Cottam Solar Project

Statement of Common Ground (DRAFT) Historic England

PINS Ref: EN010133
Document reference: EX1/C8.3.4
Infrastructure Planning (Examination Procedure) Rules 2010

Drawing file: EN010133 / EN010133-001258-Thorpe medieval settlement, Thorpe in the Fallows - 1016978 _ Historic England.pdf

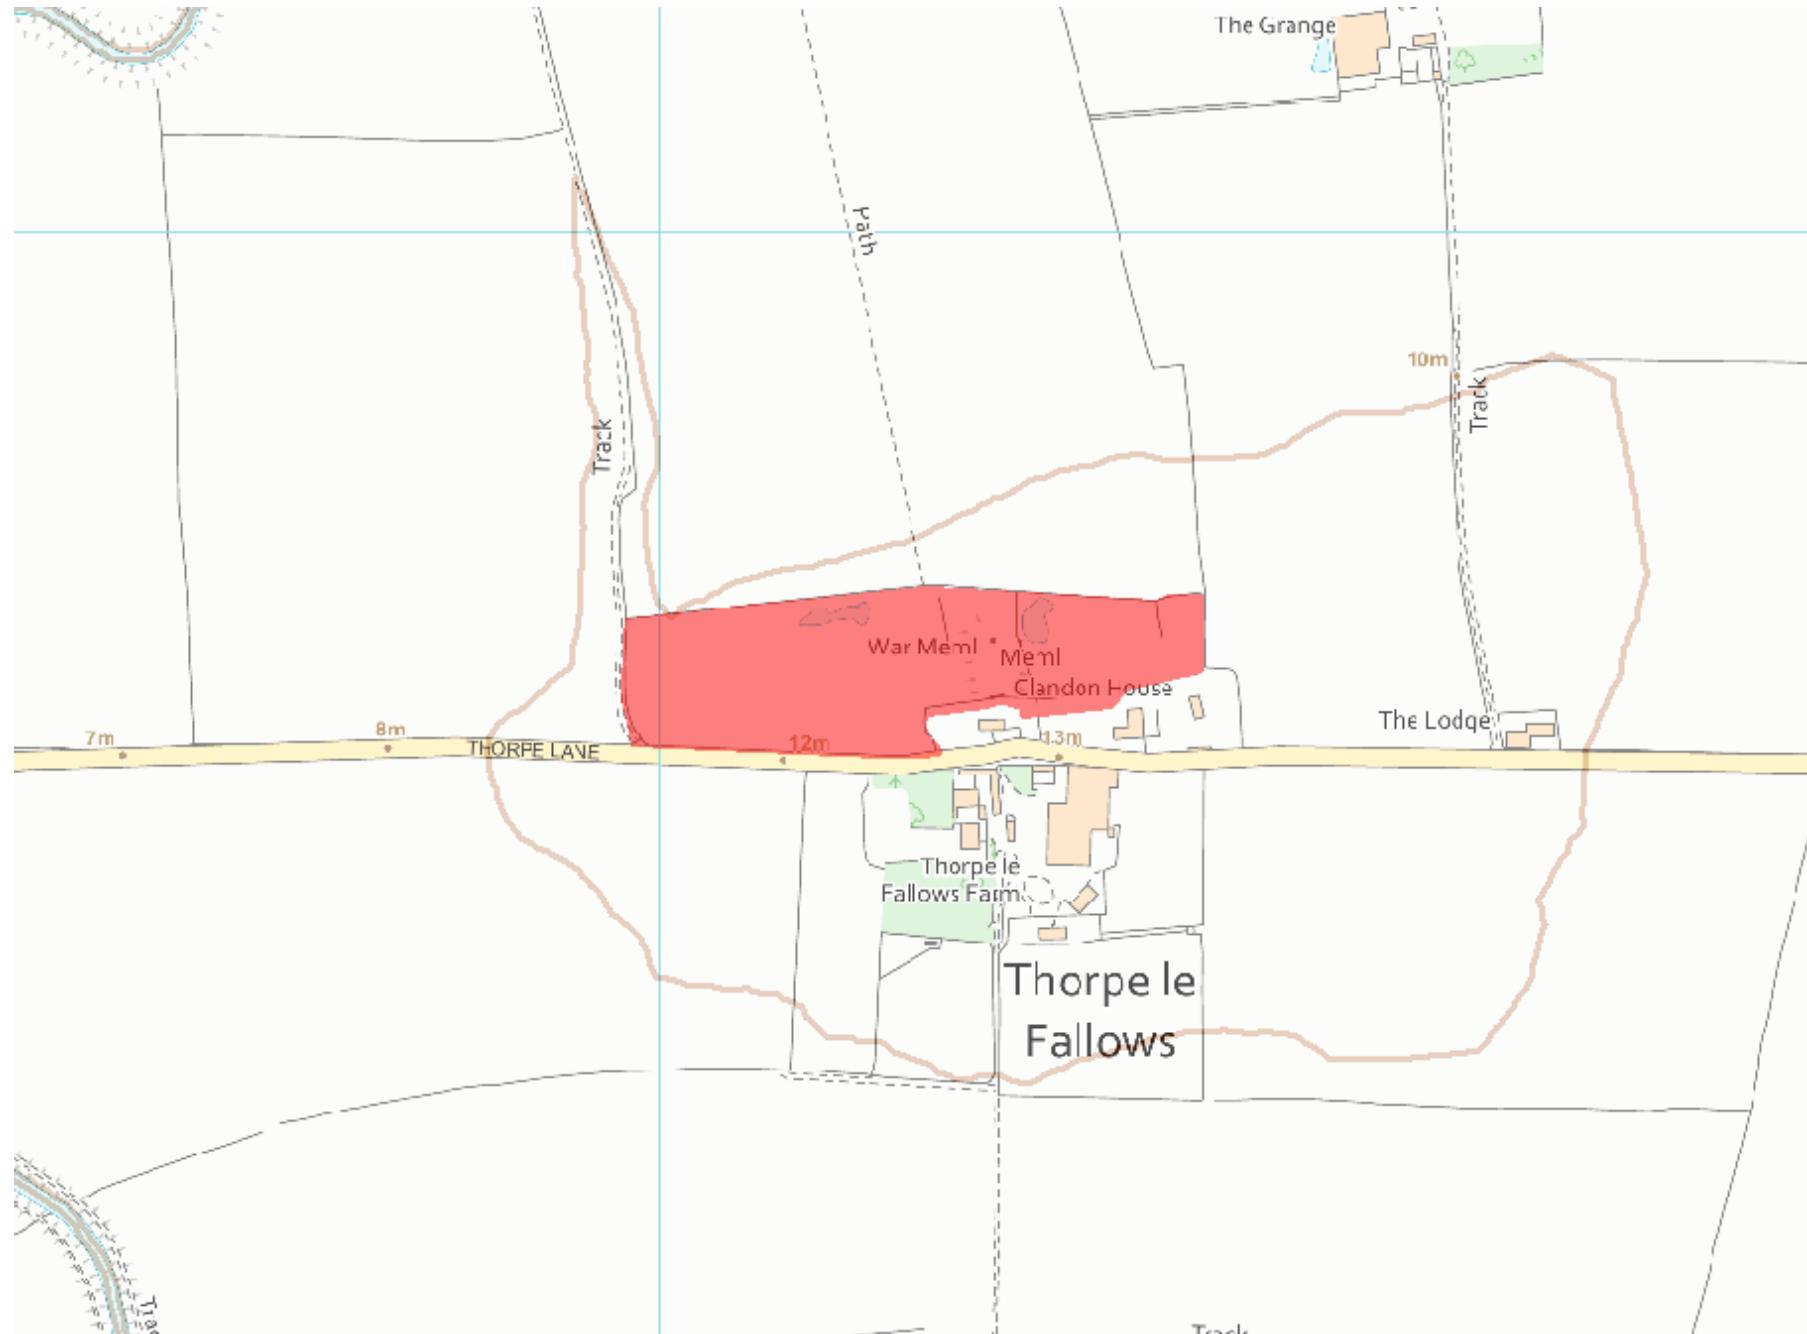
<p>HE considers the 50m buffer between the Thorpe in the Fallows shrunken Medieval Village (SMV) Scheduled Monument (1016978) and the solar panels is insufficient and does not address the impacts caused by the Scheme to the significance of the monument. HE recommends that the panels are removed between the SMV and a former historic east-west boundary recorded on the 1886 25-inch Ordnance Survey (OS) map (approximately along the line of grid points: SK90976 80920, SK91149 80944, SK91330 80904 and SK91351 80909). HE also stated that the design of the Scheme should look to recreate the character of the former field boundary i.e. a new hedgerow is planted along the rough course of the field boundary as recorded on the 1886 OS map.</p> <p>The Applicant explained their understanding of the relationship between the Thorpe in the Fallows SMV and the field to the north of the SMV. Namely, the SMV derives significance from the visual relationship with the fossilised medieval field boundaries that form the east and west boundaries of the field in question. Additionally, the SMV draws significance from the agricultural character of the open field, as historically the field would have formed an element of the agricultural land cultivated by the residents of Thorpe in the Fallows. The Heritage Statement has established the proposals will obscure views of the fossilised field boundaries and have an industrialising effect on the character of the field. The proposed 50m set back is intended to provide a buffer zone that illustrates the distinction between the SMV and the solar farm as well as providing a strip of land that illustrates the agricultural character of the field. The proposed set back will not avoid obscuring the fossilised field boundaries or having an industrialising effect on the character of the field. The Applicant believes the current proposed set back will achieve its intended aims. The increased set back suggested by HE will also provide a buffer and illustrate the historical agricultural nature of the field, but to no greater extent than the 50m set back and the increased set back would still obscure views of the fossilised field boundaries from the SMV as well as having an industrialising effect on the character of the field.</p> <p>The Applicant then enquired to HE's reasoning for off setting panels to the former east-west field boundary recorded on 19th-century historical maps, as desk-based research undertaken by the Applicant has demonstrated that there is no direct historical relationship between the scheduled Thorpe in the Fallows SMV and the east-west field boundary. During the medieval</p>

Topic	Sub-topic	Details of Matters Under Discussion
<p>HE-2</p> <p>Approach to safeguarding designated heritage assets</p>	<p>Scheduled Monument Thorpe medieval settlement (NHLE ref 1016978)</p>	<p>HE is in agreement with the Applicant that the potential impact of the Scheme on the setting of Scheduled Monument Thorpe medieval settlement (NHLE ref 1016978), as identified in ES Chapter 13 [EN010133/APP/C6.2.13], is ‘moderate adverse’ – ‘significant’, which equates to less than substantial harm using NPS/NPPF classification.</p> <p>To mitigate against any potential impacts to the setting of Thorpe medieval settlement (NHLE ref 1016978), and in response to comments by HE during a site visit on 13.05.2022, the proposed development has been offset c.50m from the northern edge of the Scheduled Monument. In addition, a hedgerow is proposed to be located to the north of Thorpe in the Fallows to provide screening between the village and the Scheme.</p> <p>HE considers the 50m buffer is insufficient and does not address the impacts caused by the Scheme to the significance of the monument. HE recommends that the panels are removed between the SMV and a former historic east-west boundary recorded on the 1886 25-inch Ordnance Survey (OS) map (approximately along the line of grid points: SK90976 80920, SK91149 80944, SK91330 80904 and SK91351 80909). The design of the Scheme should look to recreate the character of the former field boundary.</p> <p><i>“The historic agrarian setting of the Thorpe le Fallows scheduled monument is important to its significance as the remains of a rural medieval settlement. Further to our rejection of the proposed c50m offset as insufficient to address the setting of the monument, we have advised that this specific field boundary should be reinstated as a limit to the solar array. This former boundary has a direct historic landscape relationship to the shrunken settlement remains to its south and the rising round upon which Thorpe le Fallows sits. The irregular line of this east-west boundary as shown on</i></p>

<p>period the landscape to the north of the SMV was likely to have formed large open agrarian fields. This is evidenced by the north-south orientated field boundaries running to the north of Thorpe in the Fallows SMV, which fossilise the former regimes of medieval cultivation; they have a clear reverse 'S' form indicative of medieval ridge and furrow. It can therefore be assumed that the east-west field boundary to the north of Thorpe in the Fallows post-dates the medieval village, and was in operation from post-medieval period until its removal during the second half of the 20th century.</p> <p>HE is of the opinion that by siting solar panels further away from the scheduled area, it would also reduce their prominence and therefore impact to the setting of the SMV. Their view was that the field boundary supplements the evolutionary history of the Thorpe in the Fallows Scheduled Monument as there is a structural relationship between the SMV and the transitional historic landscape to its north. Therefore, although the field boundary post-dates the medieval village, it helps to enhance the transitional historical setting of the SMV and allows the scheduled monument to be experienced in a more structured way.</p> <p>The Applicant believes that by removing panels between Thorpe in the Fallows and the former location of the east-west field boundary to the north of the village, as depicted on the 1886 OS map, the Scheme is respecting a post-medieval landscape, the setting and character of which are distinctly separate to the SMV and its immediate hinterland. By recreating the character of the field boundary recorded on the 1886 OS map, the Applicant believes there is the potential to alter the character of the setting of the medieval village, which would have been formed of large open fields, and consequently misrepresent the experience of the medieval village. It can be noted that only minor evidence of the field boundary was identified during the field evaluation. Geophysical survey identified a fragmented and dispersed series of anomalies suggestive that the feature had been ploughed out. Two evaluation trenches were targeted on the field boundary, based on historic maps and anomalies identified through the geophysical survey, but failed to identify any associated remains. This may be suggestive that as well as being transient within the post-medieval period, it was also of a relatively shallow construction.</p> <p>The Applicant also highlighted the temporary nature of the Scheme, as following decommissioning, the fields can be returned to their present state. The recreation of the former</p>

<p>east-west field boundary would be problematic. In isolation the field boundary has a questionable heritage value, for example there should be a preference to preserving views between the SMV and the north-south orientated field boundaries running to the north of Thorpe in the Fallows SMV, which fossilise the former regimes of medieval cultivation.</p>
--	--	--

<p><i>the 1st edition OS 1:2500 mapping suggests it sat in an organic relationship to the pattern of open-field cultivation stripes and associated land tenure, in contrast to the straighter more regular subdivision of strips characteristic of more structured enclosure. The significance of the monument is not set in a singular medieval moment of fully open fields and peak population that can be juxtaposed to an equally static post-medieval landscape of depopulation and enclosure. Central to the understanding and appreciation of shrunken or deserted medieval villages is that the archaeological remains we encounter relate to complex and extended processes of social and economic change; sudden changes may occur but they do not define the limit of interest or understanding. Significance is therefore [diachronic] concerned with the history and evolution of the monument in this landscape rather than [synchronic] confined to certain particular points in time. We have set out a reasonable measure to conserve and better reveal the significance of the scheduled monument, and reframe it in the context of the harm resulting from development's transformation of its agrarian setting. The reinstatement of this former boundary as a limit to the solar array is both proportionate and necessary to a sustainable planning outcome. The irregular character of the boundary is important to the effectiveness of this mitigation, any functional straight-line security fencing would need therefore to sit north of the reinstated boundary. To be effective as mitigation the reinstated boundary would need to be a laid hedgerow and would benefit from the inclusion of some standard trees for instance crab apple, field maple etc."</i></p> <p>Although the Applicant appreciates HE's position that the former east-west field boundary to the north of the village is a vital aspect of the evolution of the landscape to the north of the village and so helps create a structured relationship between the of the village and its immediate hinterland, with respect to the transitional historic character of Thorpe in the Fallows (meeting dated 22.06.2023), the Applicant believes that the east-west field boundary quintessentially belongs to a post-medieval to early modern landscape characterised by small enclosed fields, which is in direct contrast to the medieval landscape which was formed by large open field systems. The scheduling of the Thorpe in the Fallows SMV pertains only to the medieval village, and so as such</p>

<p>does not relate to the later post-medieval landscape. Therefore, the Applicant respectfully disagrees with the deduction that the former east-west field boundary contributes to the significance of the scheduled SMV, and that removing solar panels between the SMV and the field boundary would enhance the experience of the heritage asset/reduce impact.</p>
--	--	--
